# DELEGATED HOUSEHOLDER DECISION

49 ASPEN GROVE EASTCOTE

Conversion of roof space to habitable use to include a rear dormer, 3 front roof lights. Erection of a single storey rear extension. (Application for a Certificate of Lawful Development for a Proposed Development)

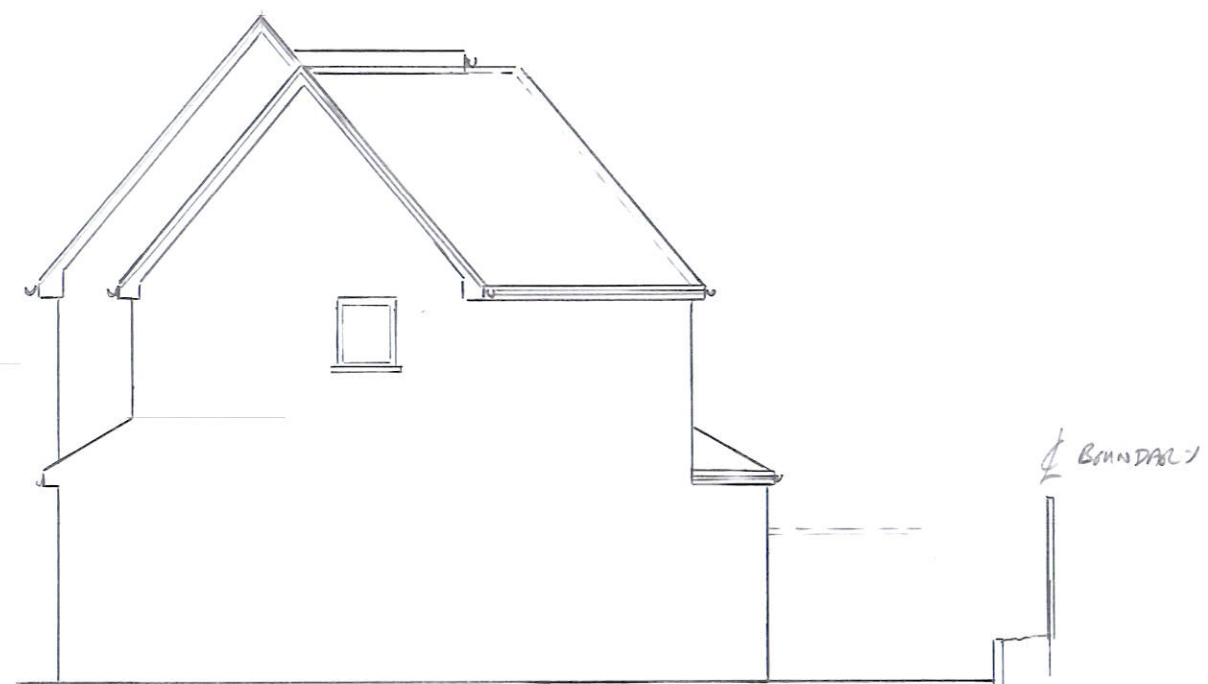
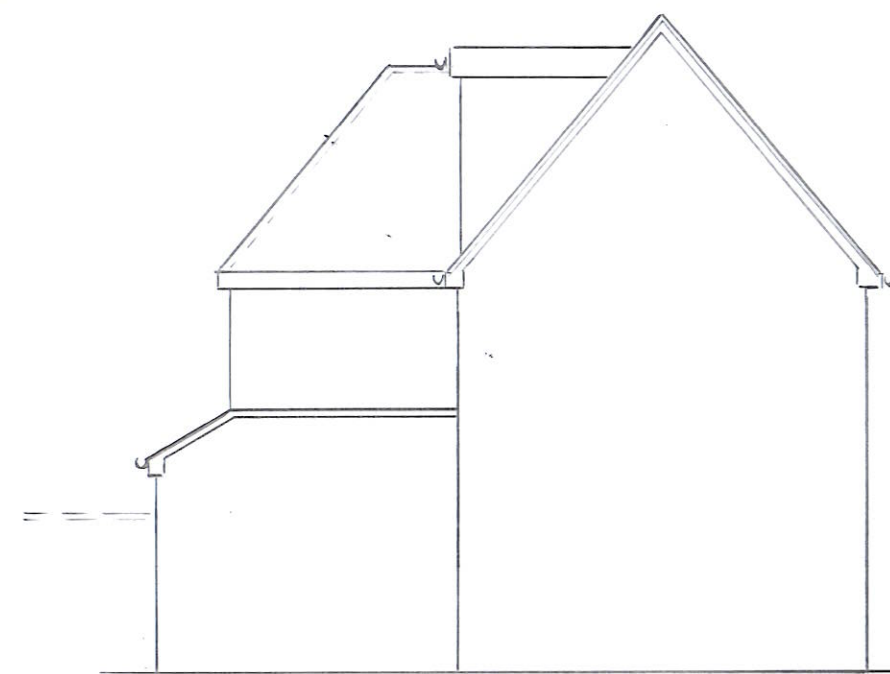
The proposed side extension is set to be flush with the front building line with the two storey element being set back 1m from the front and would be 3.3metres in width, it would connect with a single storey rear extension that extends 4metres beyond the rear elevation. The side extension would therefore have a length of 9.35metres (including the single storey rear element). Although, this is compliant with DMHD1 whereby the front elevation of the side extension is set back; given the design of the host dwelling and the addition of this element would constitute as overdevelopment; disrupting the consistent development pattern of the other homes which all have identical architectural design. Furthermore, should this proposal be approved, the development of this side element would eradicate the space to the side of the property which has been designed to ensure that the plot maintains openness in the area, especially seeing as the property is located in a way that the development can be seen from a public vantage point.

The side extension adjacent to the host dwelling would be characterised by a gabled roof that extends 8.2metres in height. The height to the eaves would be 5.2metres at two storey level and would project a depth of 9.2m in total. The gabled roof would project beyond the rear elevation by 70cm over part of the side/rear extension. Whilst the roof pitch matches that of the main gabled roof to the front and side, to the rear it would have a hipped element which would create an awkward visual relationship with the main roof. The combination of this element with the rear dormer further exasperates the scale and bulk of the development. The overall scale and size of the development would fail to appear subordinate to the existing dwelling and the site as a whole. This still creates a discordant addition due to the width and bulk of the side extension which is exacerbated by the overall height and massing of the roof profile. The finishing roof form and height provides an awkward and jarring relationship with the existing building that would be overwhelmed by the extent

The length of the side extension would also appear highly visible due to the prominent position and proximity to the street. Given that the side element would be flush with the front building line, and despite the two storey side element having a set-back; due to the bulk, height and massing of the extension, the development would detract from the scale and proportions of the existing dwelling and appear insubordinate to it.

The proposed rear dormer would have 30cm side set-ins from the gable ends, would be set down 45cm from the ridge. The rear dormer occupies the majority of the rear roof slope and would be highly visible from the street scene and rear gardens of surrounding properties. While it is acknowledged that there is a CLD approval on file 78143/APP/2024/2129, this dormer from a householder perspective, this would not be acceptable due to the scale and bulk of the dormer in combination with the side extension would dominate the rear elevation resulting in insubordinate and incongruous additions that visually detract from the street scene and would exceed 2/3rd of the original roof profile. It is therefore considered that the development would be harmful to the character and appearance of the existing building. Again, there are no examples of such dormers on Aspen Grove and the introduction of such a development would be harmful to the character, appearance and visual amenity of the surrounding area.

There is a ground floor window in the side (east) elevation of the proposed side extension, and this could have been obscure glazed and secured by condition, if this application had been recommended for approval.

The dormer windows would provide oblique views to the neighbouring gardens and would face towards the nursing home to the rear at some distance. As such, the proposal would not give rise to a loss of privacy or overlooking issues for the adjacent and neighbouring occupiers.

There are no proposed gable end windows indicated and in the event of planning permission being granted, a condition would have been recommended to restrict any further window openings in the interests of preserving neighbourhood privacy.

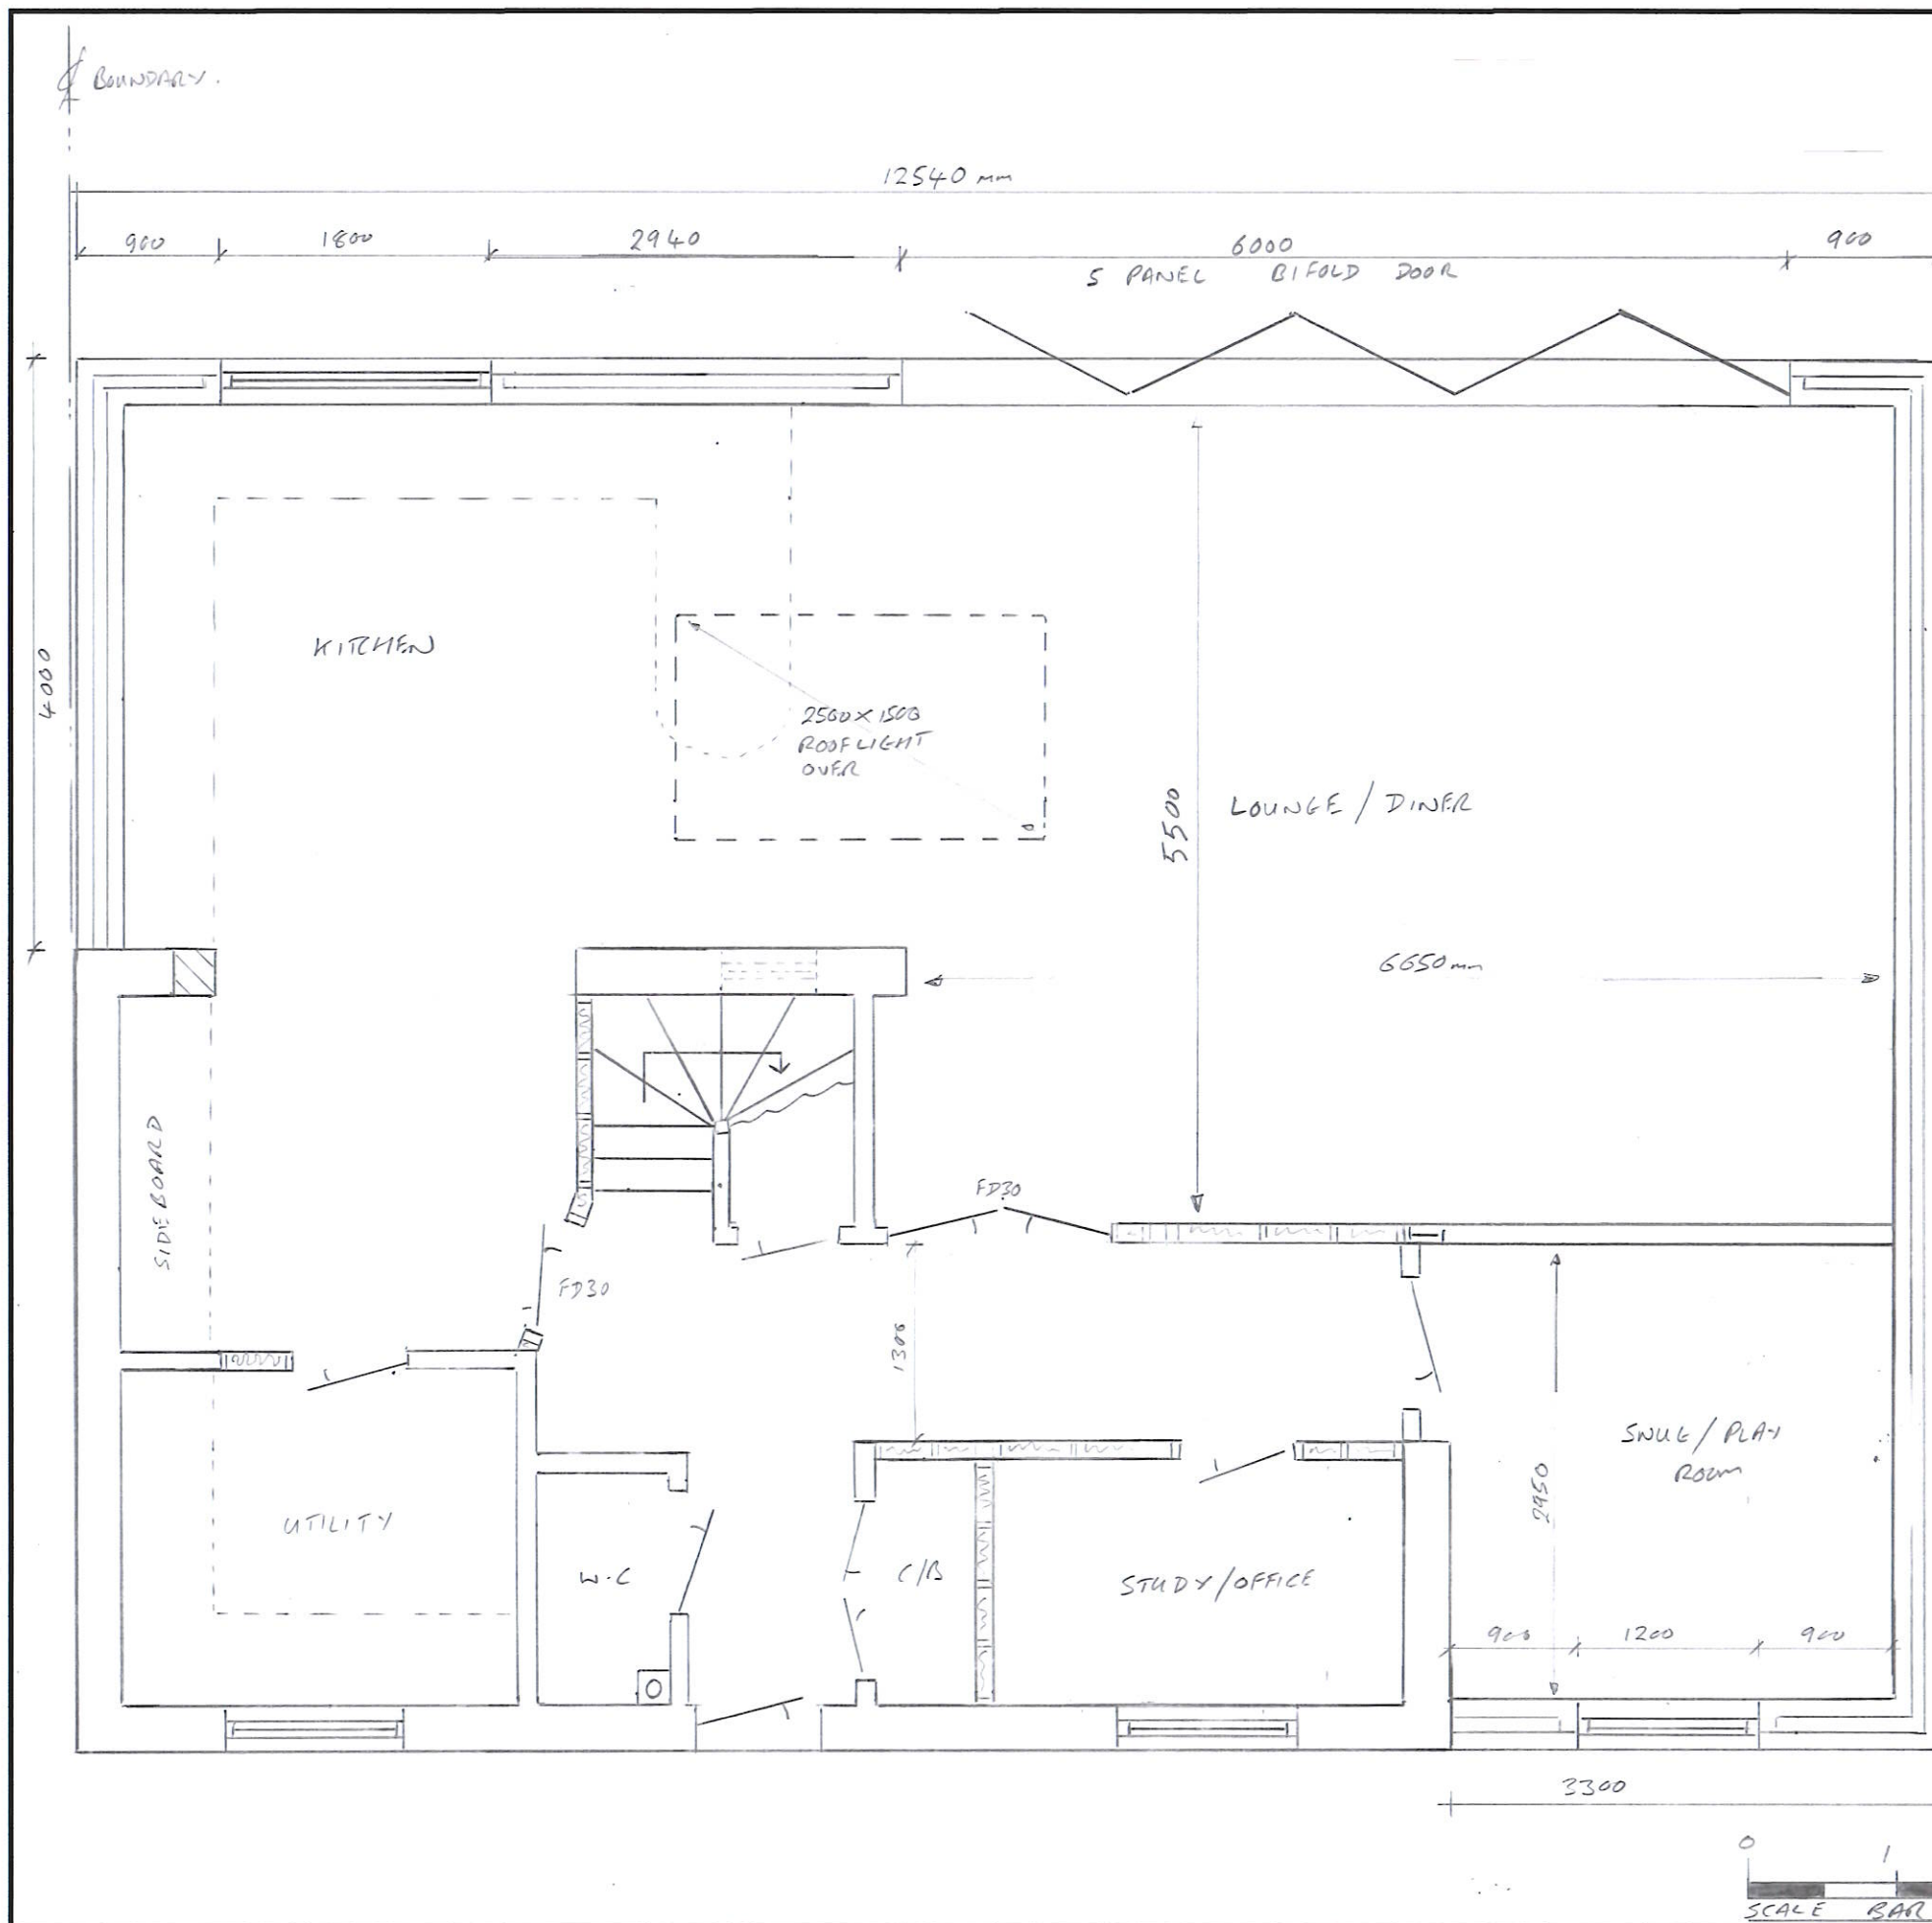
It is noted that the application erroneously states that no changes to parking are proposed. The property benefits from 2no on-site parking spaces to the side of the dwelling. As noted by the highway authority, whilst the plans show two cars parked in the garage, the size of the garage would be substandard for such provision and could only accommodate the parking of one car.

The number of bedrooms within the dwelling would increase from 3no bedrooms to 5bedrooms and there would be a net loss of 1no parking space. Aspen Grove is a planned development with limited capacity for on-street parking and as a result of the development, insufficient parking provision would be retained within the site to serve the dwelling.

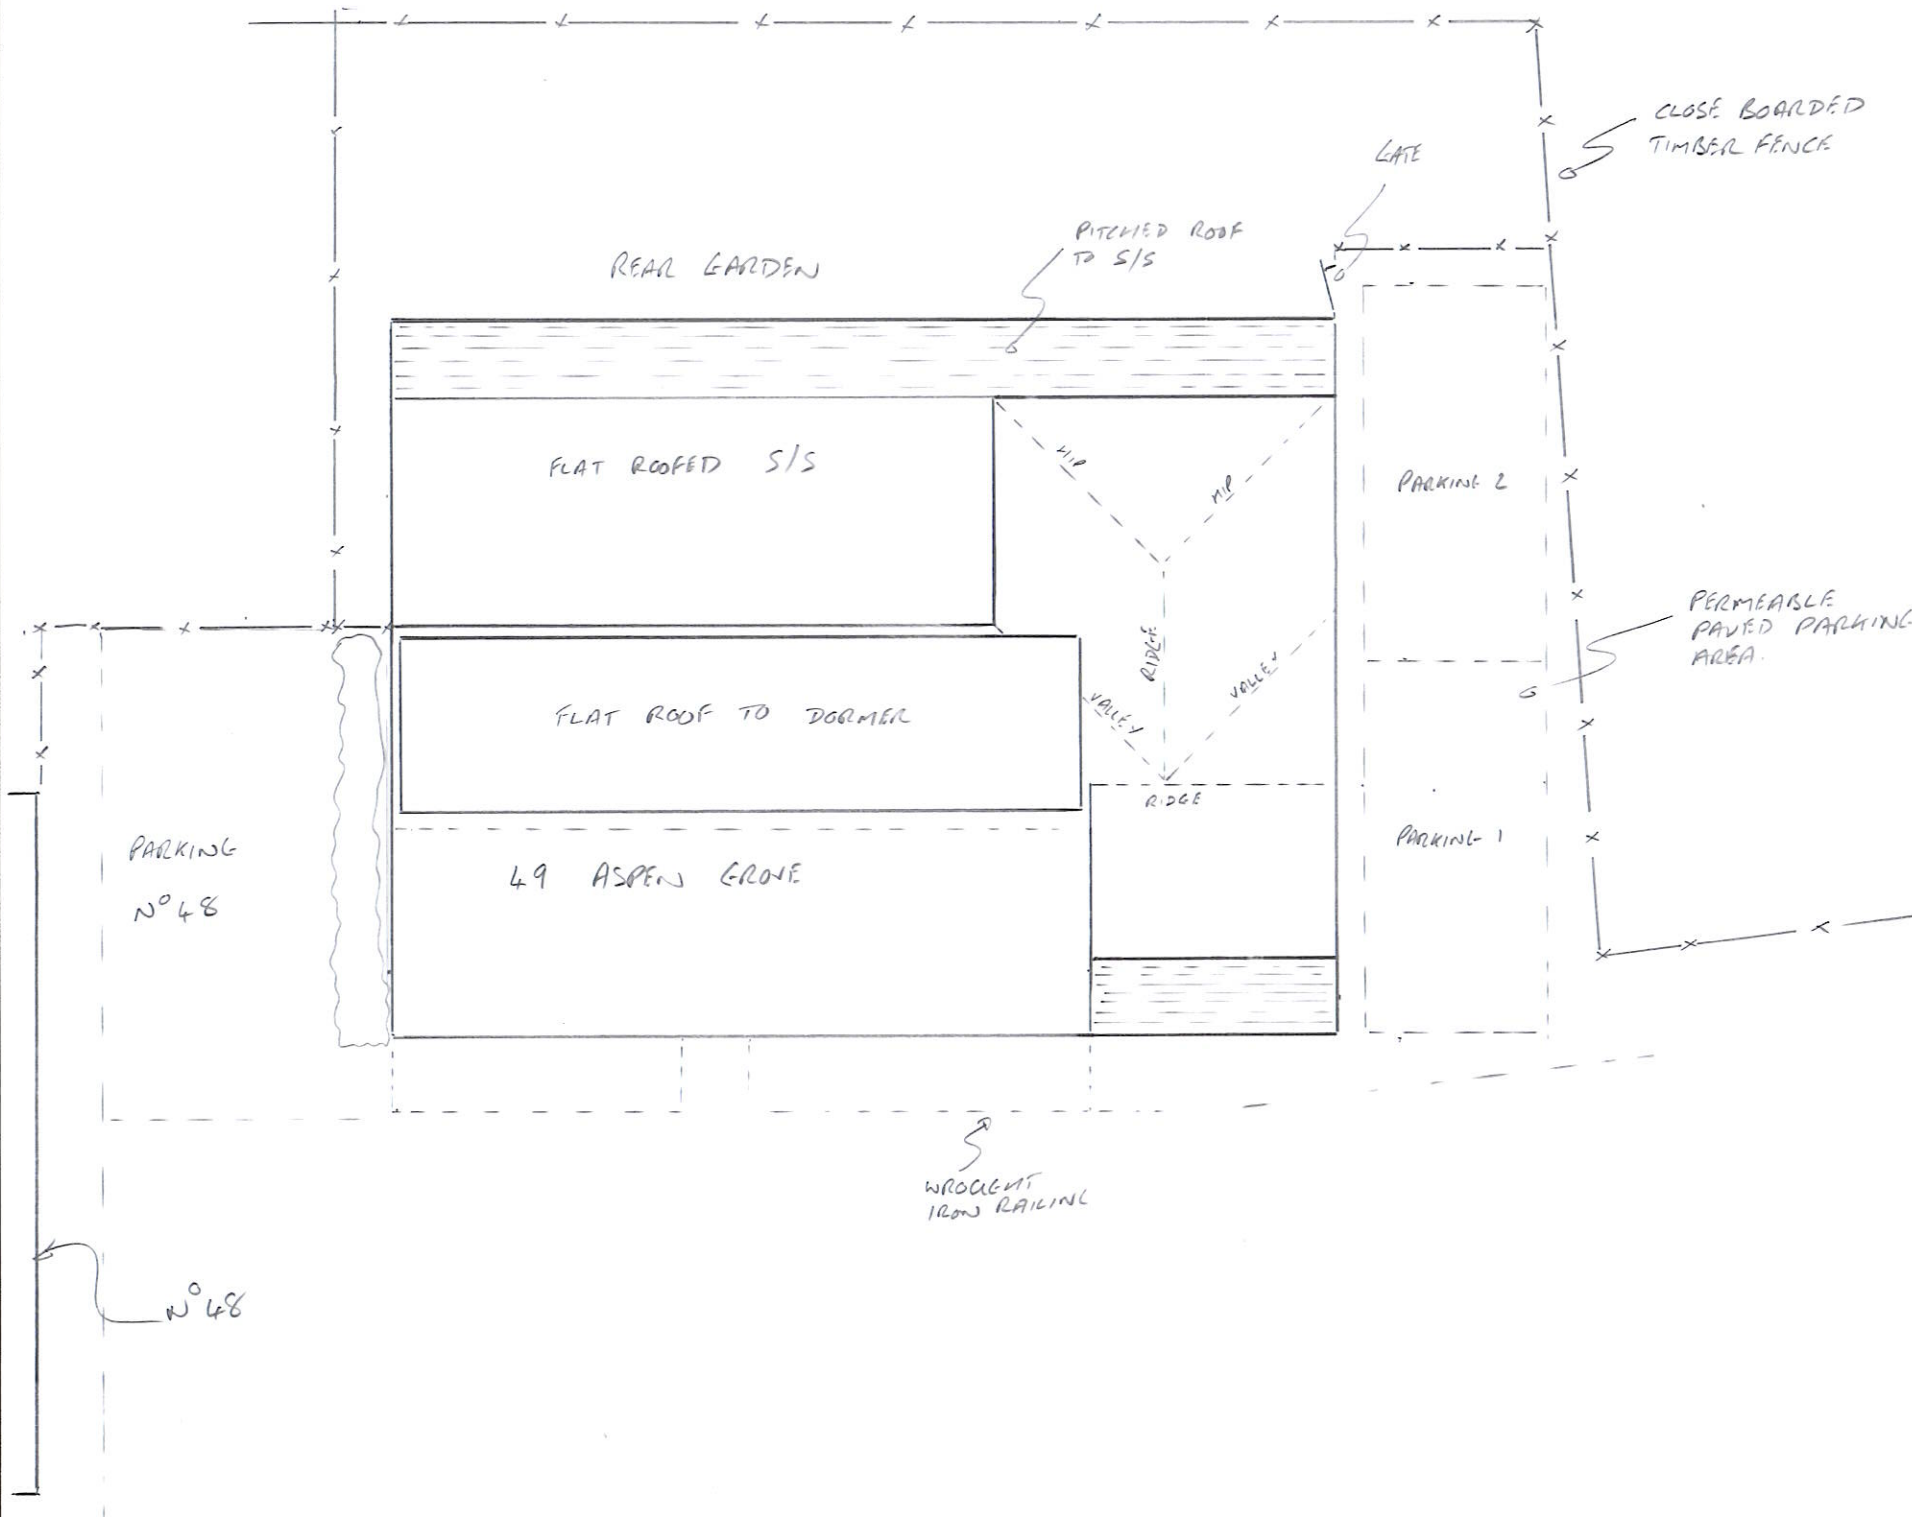
As outlined by the agent themselves, the development would result in a significant shortfall and loss of private amenity space in terms of the Local Plan's minimum requirement of 100sq.m private amenity space for a 4+ bedroom dwelling. It is therefore considered that an insufficient amount of rear garden space would be retained to meet the needs of the host dwelling.
